# **A46 Newark Bypass**

**Scheme Number: TR010065**

## **Statement of Common Ground with the Environment Agency**

**October 2024**

Figure 10: Slough Dyke realignment – extract from AS-007 (General Arrangement Plans) Sheet 25005

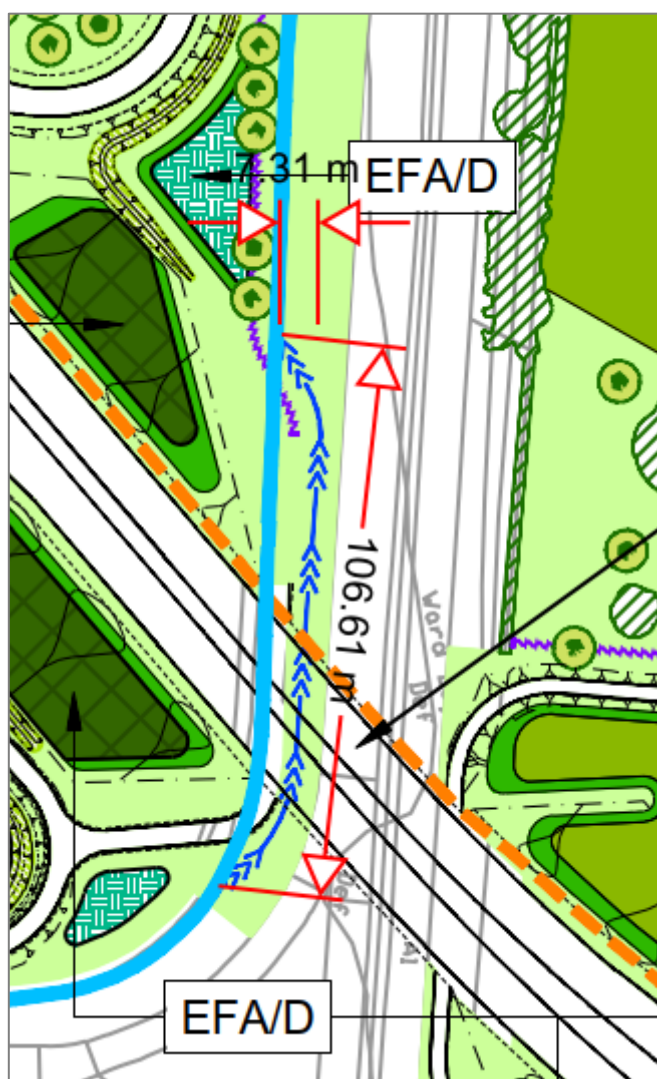
<p>Relevant Representation Reference EAFR-007 (Slough Dyke (main river) realignment) refer to document reference for issue details.</p> <p>No detailed drawings for the Slough Dyke realignment have been provided and the realignment has also not been represented within the hydraulic modelling undertaken.</p>	<p>Following a meeting to discuss the Environment Agency's relevant representation on 05/09/2024, the Applicant prepared a Technical Note to provide further detail to clarify the suitability of the fluvial hydraulic modelling outcomes. A meeting to discuss outstanding flood risk issues and the contents of the Technical Note took place on 17/10/2024. The Technical Note was provided to the Environment Agency on 22/10/2024 for their review. Following this meeting, the Applicant and the Environment Agency look to further discuss this issue.</p>	Under Discussion	
			<p>Relevant Representation Reference EAFR-009 (Climate change allowances sensitivity test) refer to document reference for issue details.</p> <p>The FRA has not assessed a credible maximum peak river flow climate change scenario, in line with GOV.UK guidance on climate change allowances for flood risk assessments. This is expected given the Scheme's status as a Nationally Significant Infrastructure Project (NSIP) and its proposed 120-year lifespan.</p>	<p>Following a meeting to discuss the Environment Agency's relevant representation on 05/09/2024, the Applicant prepared a Technical Note to provide further detail to clarify the suitability of the fluvial hydraulic modelling outcomes. A meeting to discuss outstanding flood risk issues and the contents of the Technical Note took place on 17/10/2024. The Technical Note was provided to the Environment Agency on 22/10/2024 for their review. Following this meeting, the Applicant and the Environment Agency look to further discuss this issue.</p>	Under Discussion

**Figure 3-1 Location of Cree's Lane embankment.**

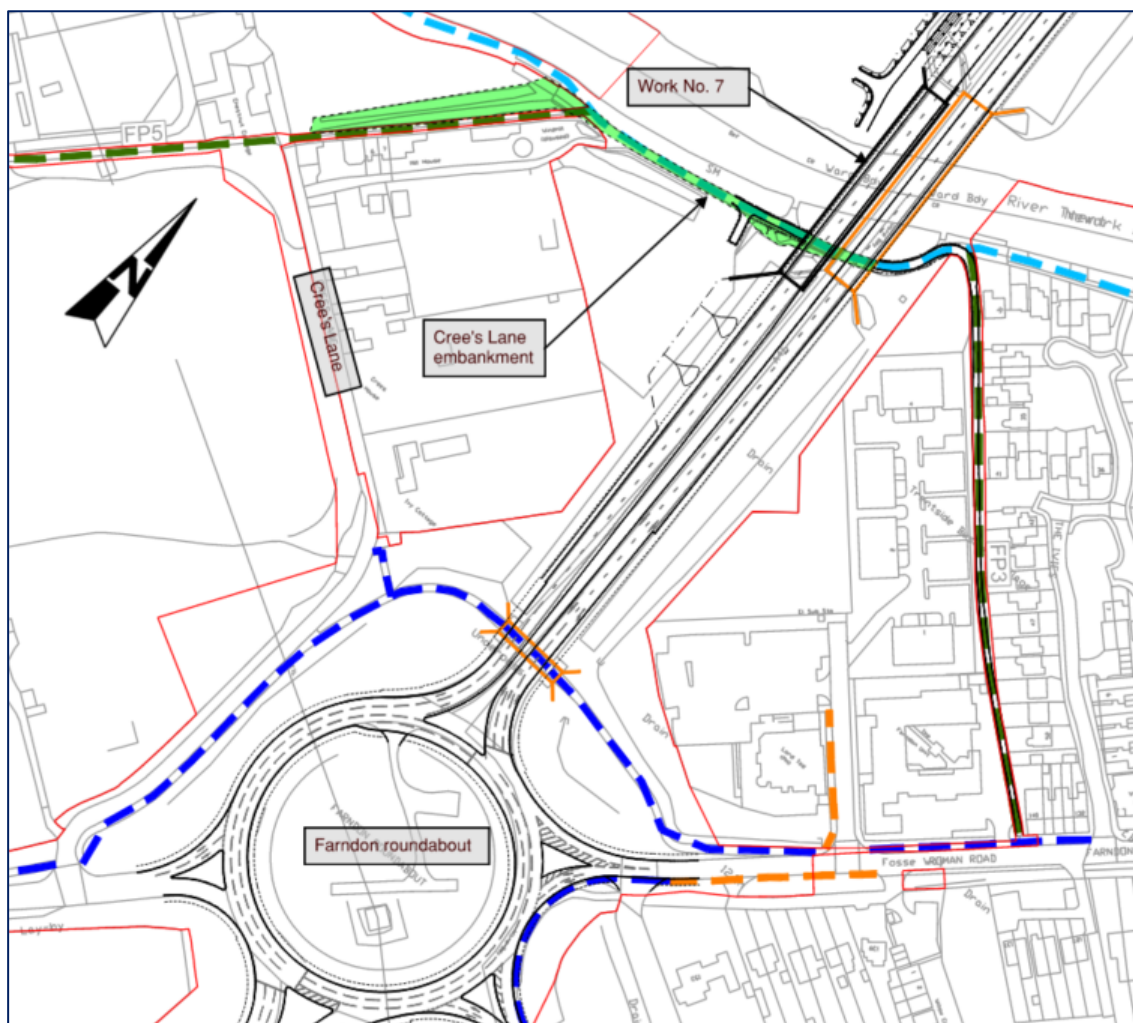
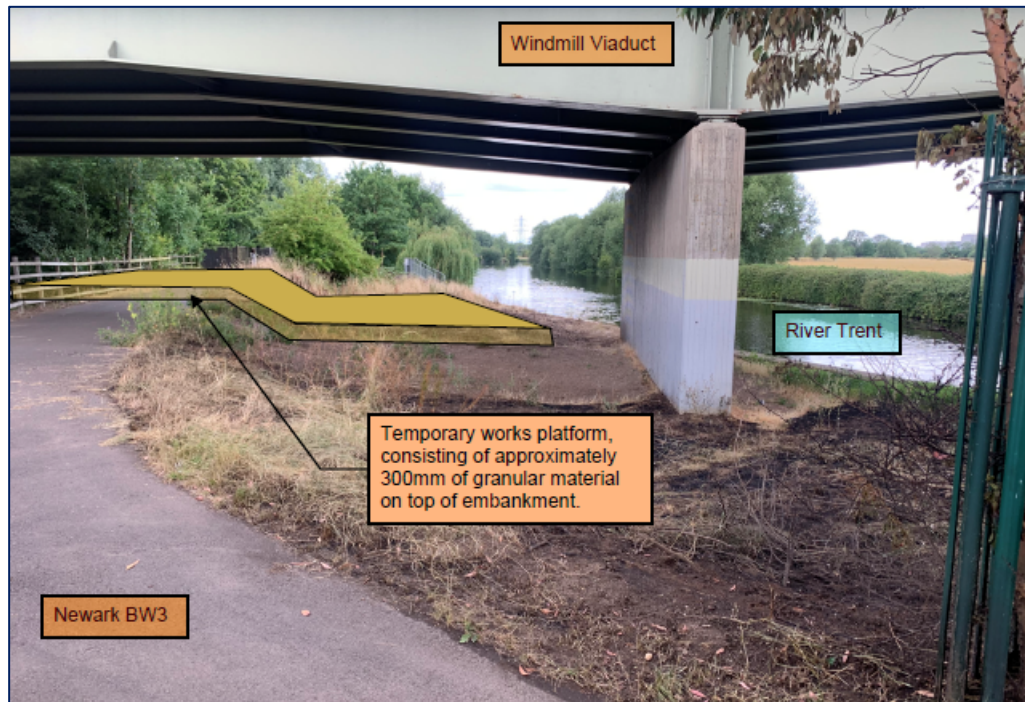
5.	Flood Risk – Interaction with Flood Defences	Appendix 13.2 (Flood Risk Assessment) of the Environmental Statement Appendices [APP-177]	<p>Relevant Representation Reference EAFR-008 (Interaction with Environment Agency flood defences) refer to document reference for issue details.</p> <p>There is limited information available on the Scheme's interaction with the existing Environment Agency flood defences. The FRA mentions that the Scheme will 'tie-in' with existing Environment Agency flood defences (see</p>	<p>The Applicant confirms the Scheme interacts with two Environment Agency flood defences. Information on the flood defences was discussed with the Environment Agency on 5 September 2024 in a meeting.</p> <p>The Crees Lane Embankment is a 239 metre long flood defence embankment which is located on the south bank of the River Trent between the A46 and Cress Lane. The embankment is constructed from clay with a clay key penetrating 1 metre below ground level. An access track, including bridleway 2, is located on top of the embankment.</p>	Under Discussion

Issue No.	Issue	Document Reference	Environment Agency Position	National Highways' Position	Status	Date status confirmed
		Works Plans [AS-005]	paragraphs 3.4.2 and 7.7.2), but there is no explanation for how this will occur, or how it will be ensured that there will be no detriment to the defences.	<p>The new Windmill viaduct (Works No 7) spans over the flood defence embankment with no permanent detriment to its location or structure. The temporary works area for the construction of the bridge (Works No 127) will require a crushed stone platform to be laid to support the construction plant that will be required to construct the bridge, such as piling rigs and cranes. This stone platform would be laid against the existing flood structure and will not reduce its structural integrity. Upon completion of the new bridge structure the temporary works will be removed and the land reinstated to previous use. The bridleway (BW2) and access track (Works No 6 as shown on the Works Plans [AS-005]) are re-opened following completion of construction of the bridge and the reinstatement of Works No 127. Works No 6 provides vehicle and foot access to the Crees Lane Embankment for inspection and maintenance works.</p> <p>The Newark Roundabout Embankment is a 325-metre-long embankment located to the southeast of the A46 between Kelham Road and the southeast quadrant of the Cattle Market Roundabout. The embankment is constructed from Marl with a shear key that protrudes 1 metre into the ground under the centre of the bund. There are also two grout curtain walls through the bund.</p> <p>Works No 40 as shown on the Works Plans [AS-005] is required for the widening for the new Cattle Market junction and interfaces with the eastern end of the flood defence. The southeast corner of the new roundabout will incorporate the last 10 meters of the eastern end of the flood embankment within the earthworks for the new roundabout. The new earthworks will be benched into the existing embankment to form a solid, homogeneous structure. The flood bund will not be compromised during the construction works, and the EA's existing access will be maintained.</p> <p>In relation to Crees Lane floodbank the Standard of Protection (SOP) is demonstrated to be 1 in 100 year + 39% climate change in the Scheme hydraulic model, however other routes result in flooding behind the defence in more frequent SOPs.</p> <p>In relation to Newark Roundabout Embankment similarly, the Standard of Protection (SOP) is demonstrated to be 1 in 100 year + 39% climate change in the Scheme hydraulic model, however other routes result in flooding behind the defence in more frequent SOPs.</p>
